BR/86/20/PL

The revised proposal for Room 38 appears to be acceptable, thank you.

I have attached to this e-mail a drawing showing some additional elevations and a dormer window inserted into the roof space at the rear of Room 38 in place of what were previously two proposed velux rooflights. This dormer window will look directly towards the existing car park lying to the rear of Bickleys Court, with the view obtained by the resident not impeded by any other buildings on the application site. In this way, the dormer window is positioned centrally within the bedsit, providing natural light, adequate ventilation and importantly a view. Could you please advise me whether the details shown in the attached drawings are acceptable to you and your HMO officer, and I shall then send these amended drawings to you through the planning portal.

SECOND FLOOR / ROOF PLAN

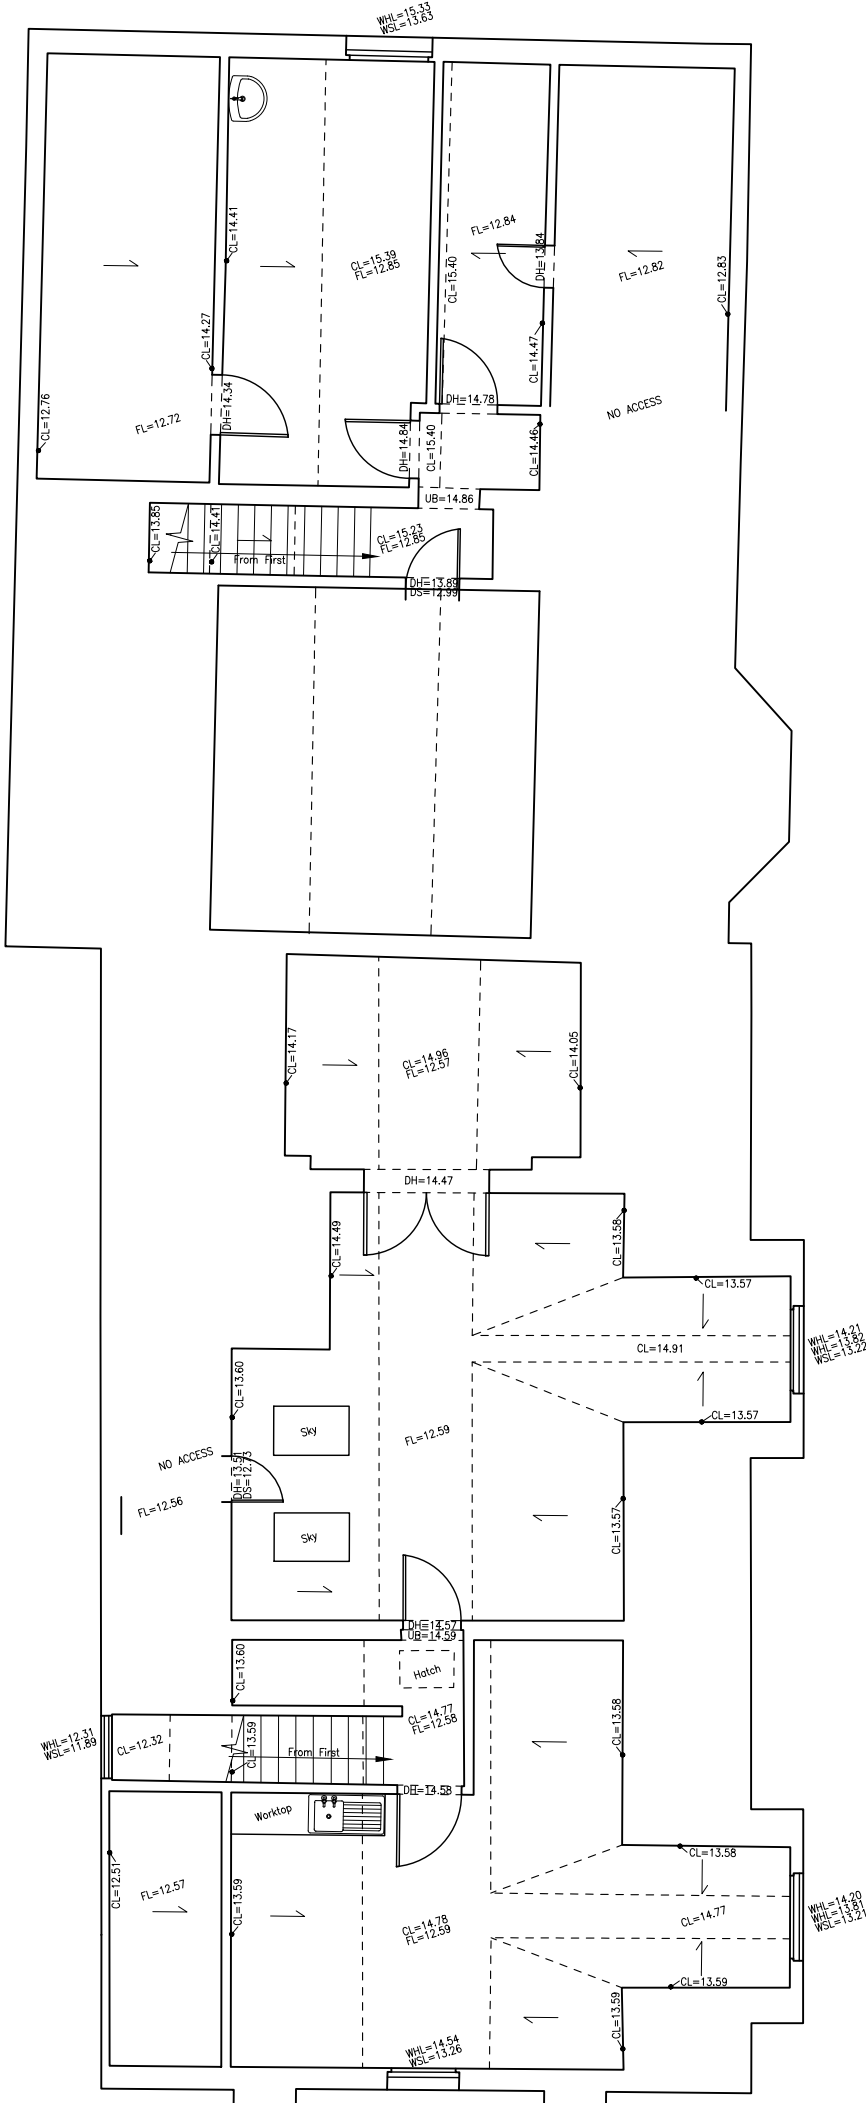
I know that I mentioned room sizes in my initial response, but a colleague has pointed out that when viewing the plans showing the bed size in relation to the useable space in the second floor bedrooms, the applicant should ensure that the correct room sizes are available as follows:

- Room sizes should meet the minimum standards for houses in multiple occupation
- The floor to ceiling height must be at least 2.1 metres from floor to ceiling over at least 50% of the floor area when measured at a height of 1.5metres from the floor and provide sufficient useable space.

- Note with regards to room sizes where cooking facilities are sited within bedsits:

10.2 sqm* – suitable for 1 person

15 sqm* - suitable for 2 persons

*measured from a 1.5 metre plane. Any area of the room with a ceiling height less than 1.5 metres is not counted and the ceiling height over at least 50% of the floor area must be at least 2.1 metres. This is detailed in the HMO Standards, but in view of my colleagues comments, I felt I should make it clear in case of any discrepancy.
